PLAN EXAMINATION RFI HOLD

PROJECT/SITE DESCRIPTION:
Maine Medical – Visitor’s Garage Extension

PROJECT ADDRESS:
22 Bramhall St – Portland, Maine

Review Type: All Trades
Plans Date: 3/9/18
of Sheets: 96
Project Area (sq. ft.): 82,201

A45-01

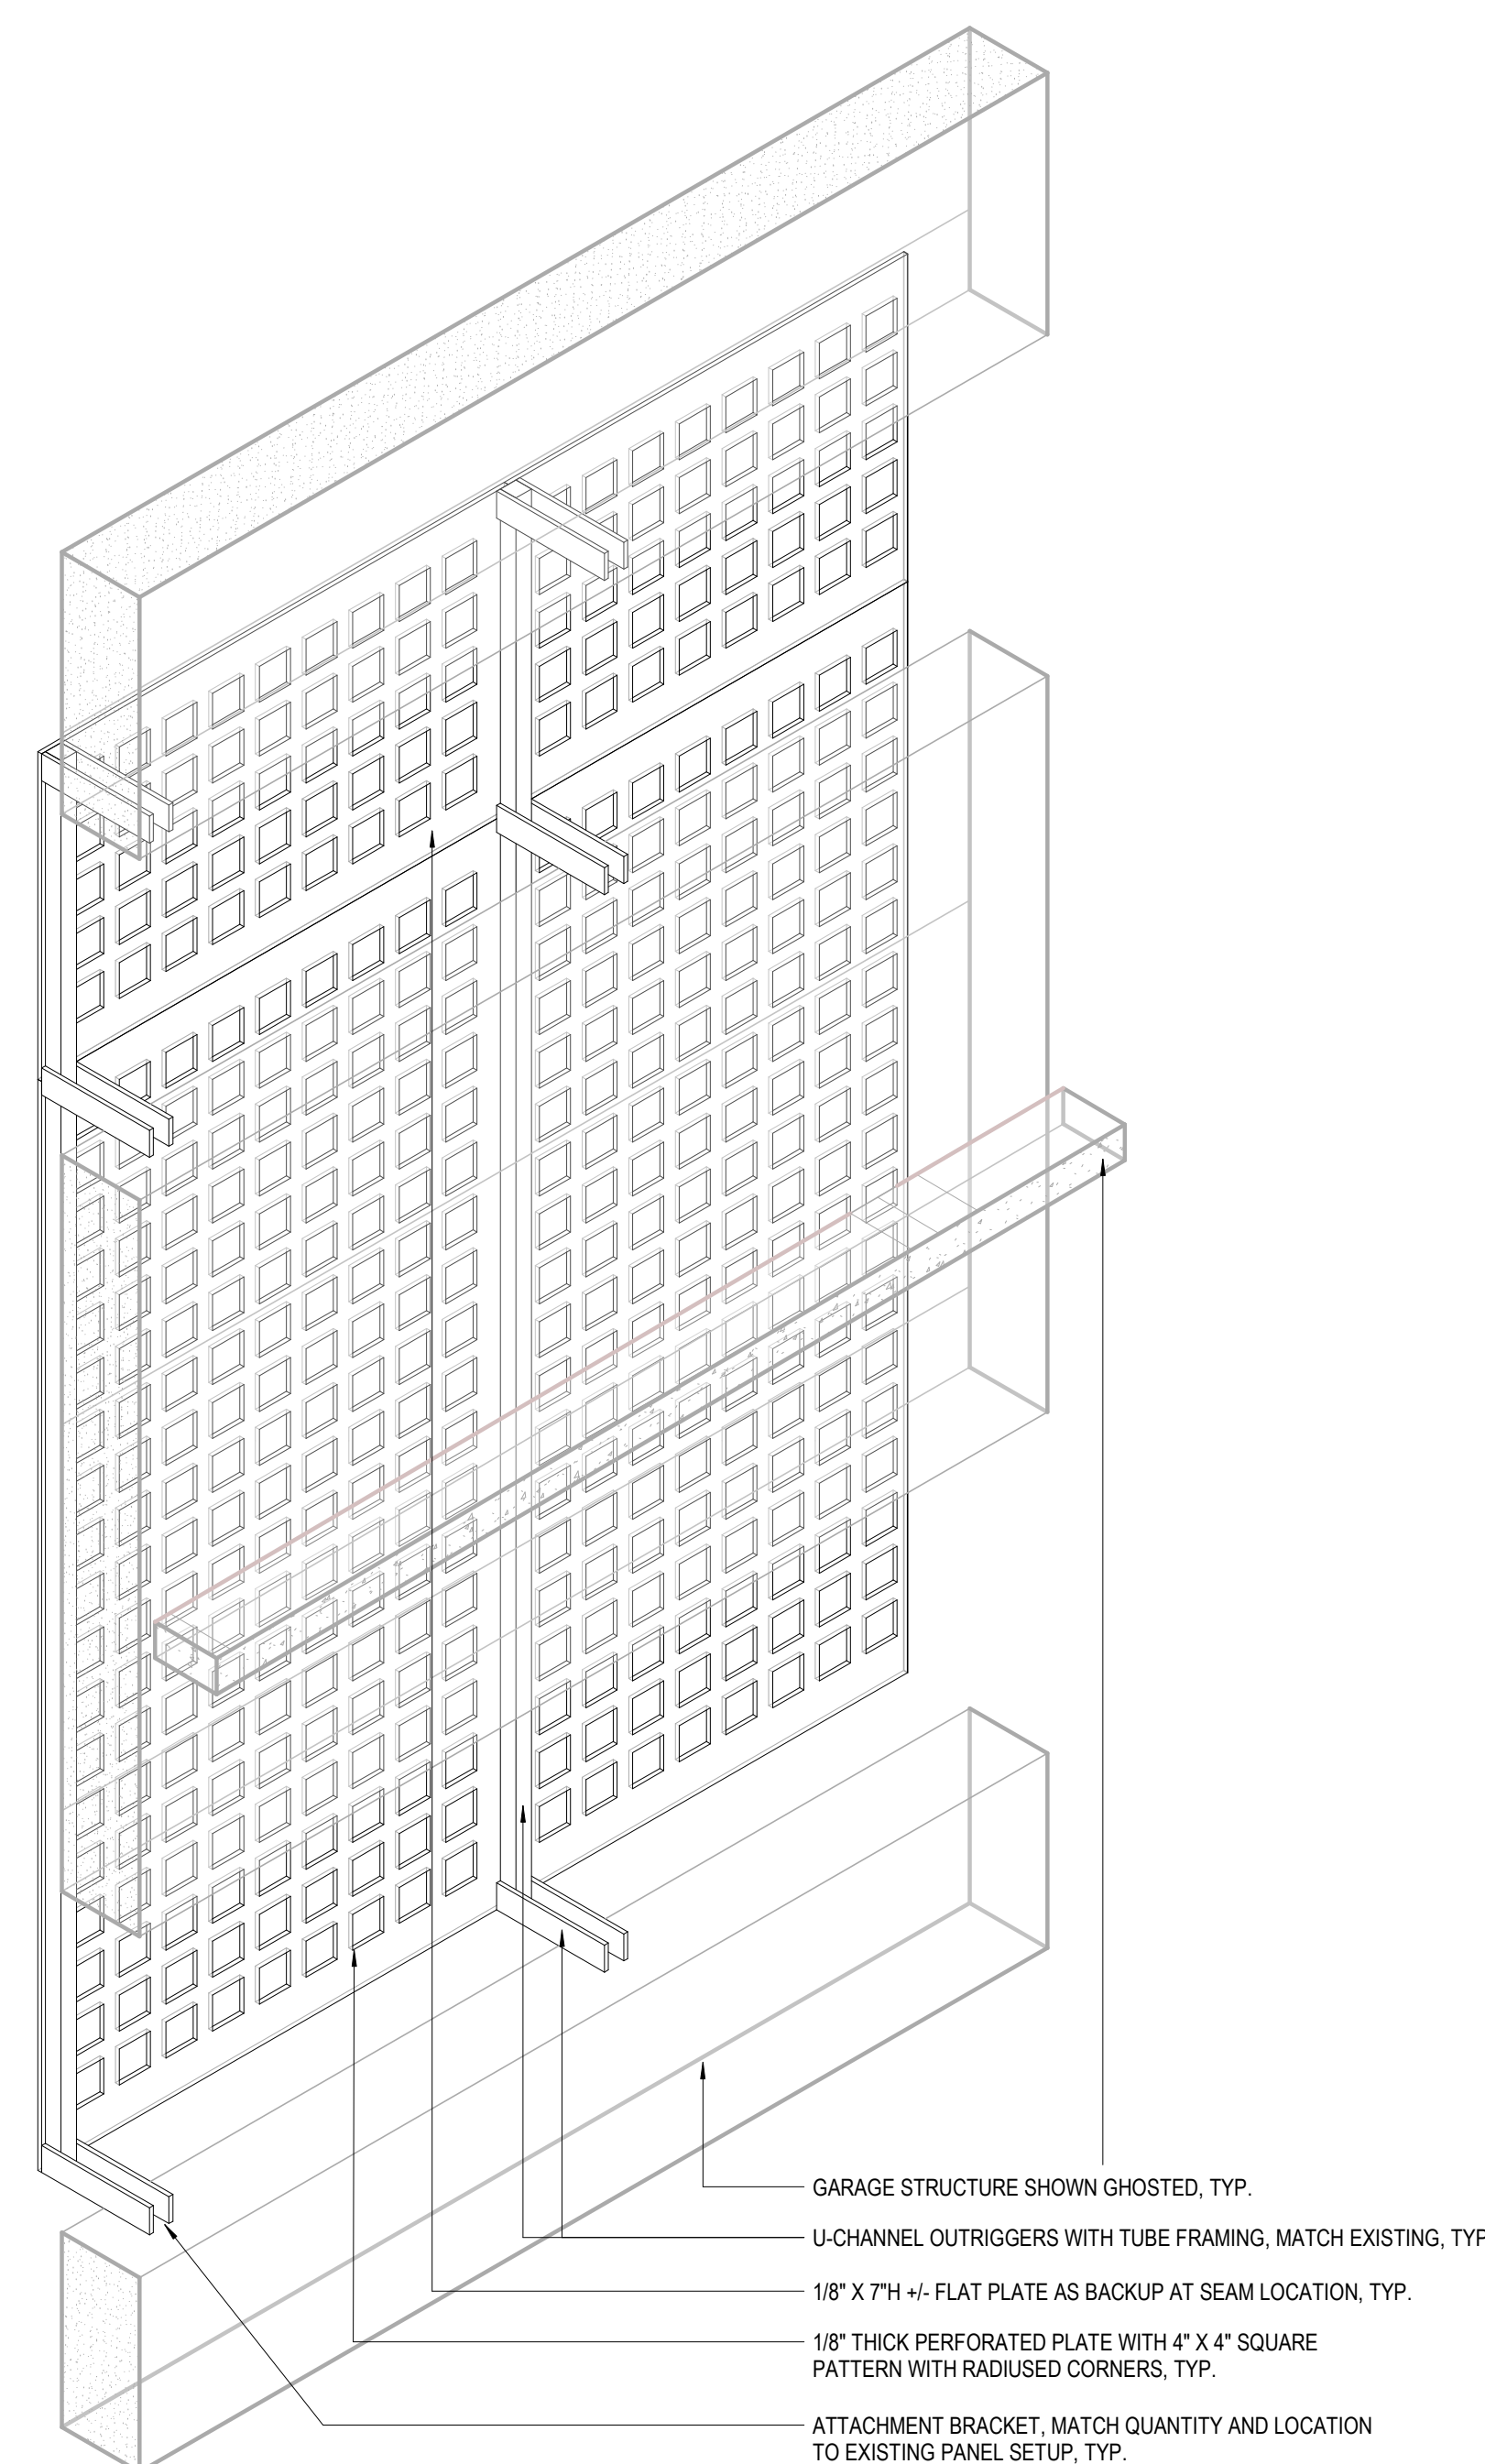
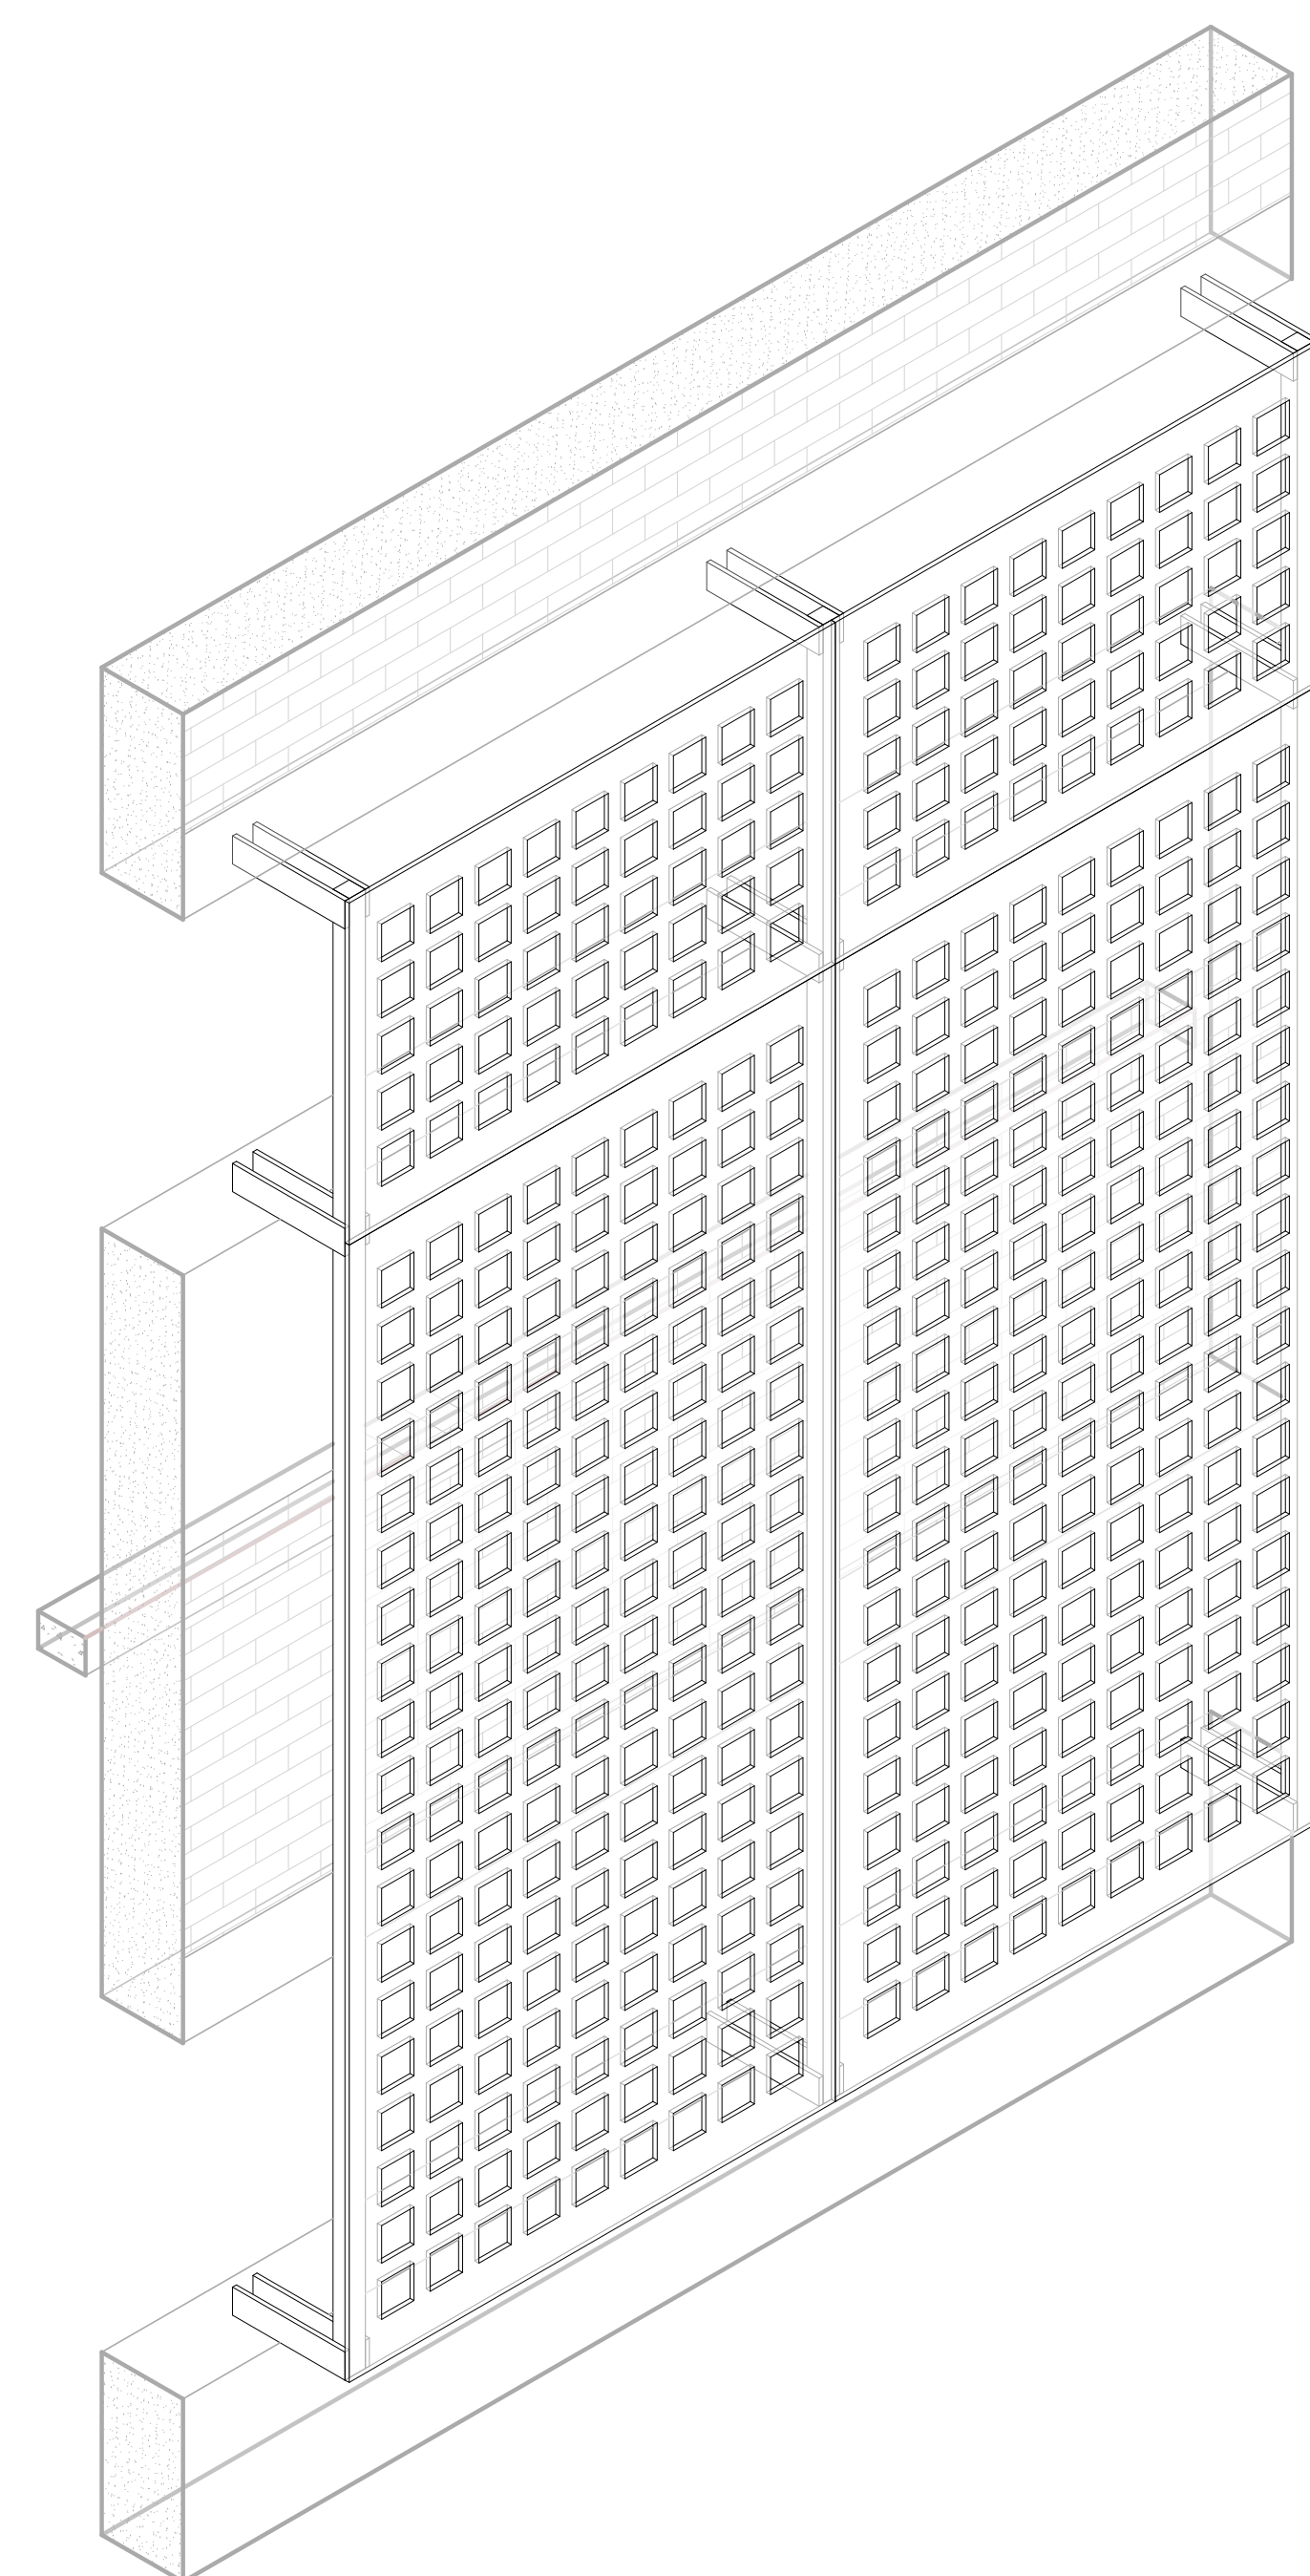
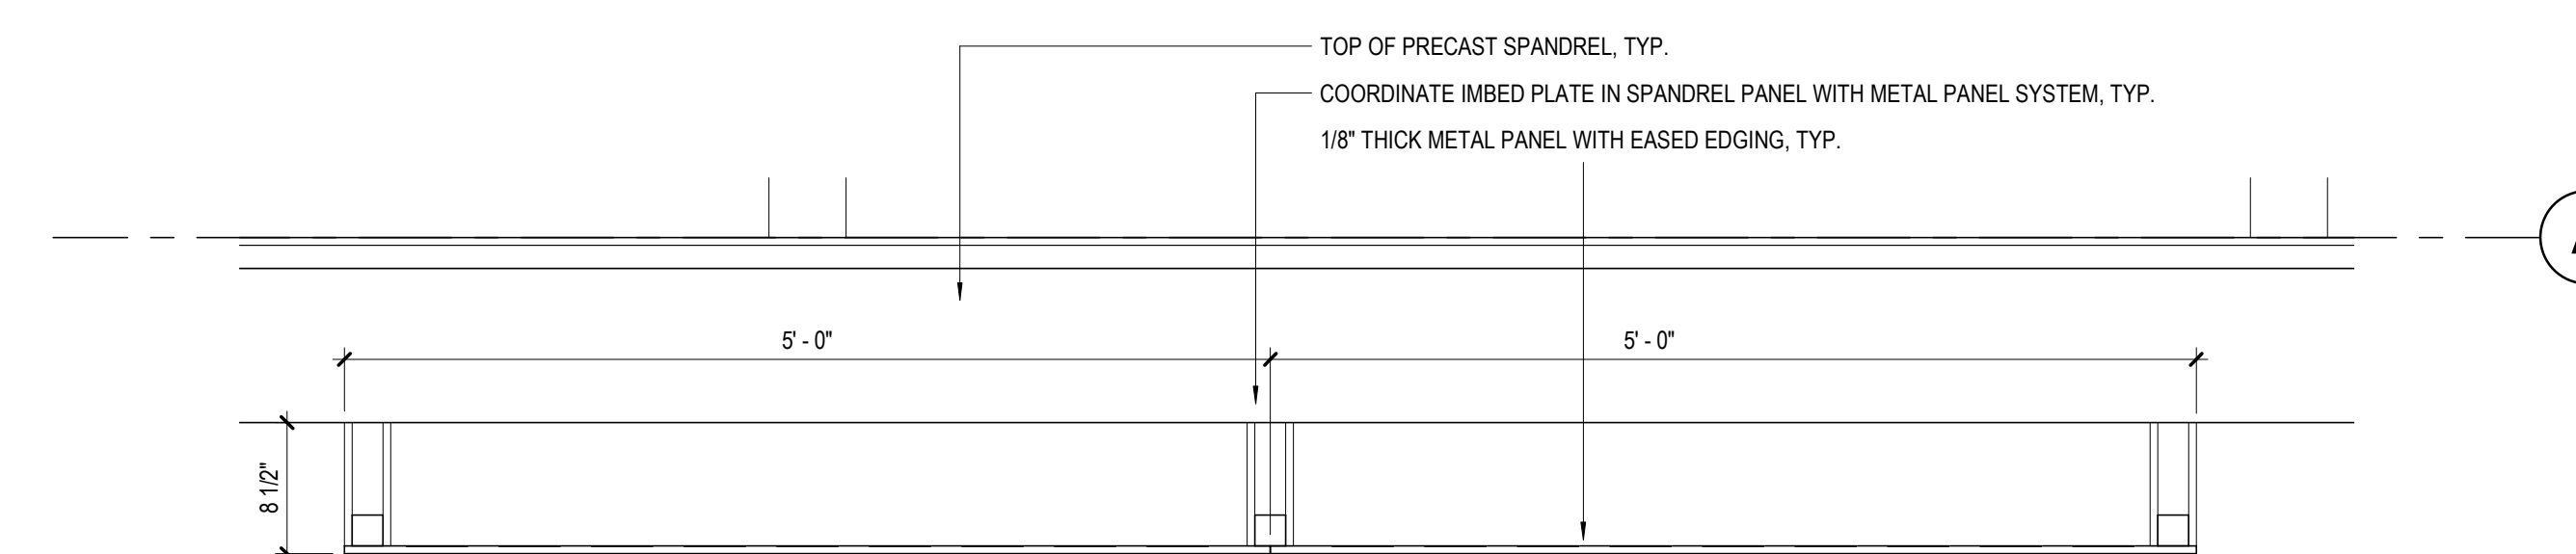
1. Architectural drawings for the decorative metal panel system, metal railing system, and fall protection fencing system (sheets A45-01 through A45-10) do not provide specific details for steel embeds or welds required for proper attachment to the precast concrete structure. Sheet A45-01 calls for the decorative metal panels to be field welded. Neither the structural drawings nor the precast panel shop drawings address these embed or welding details either. Per IBC sections 1405.11 through 1405.11.4, metal veneers on exterior walls shall be fabricated from approved corrosion resistant materials or shall be protected as described therein, attached by corrosion-resistant fasteners or other approved means, protected from the weather, and grounded as required by IBC chapter 27. Please provide additional information and revise as required.
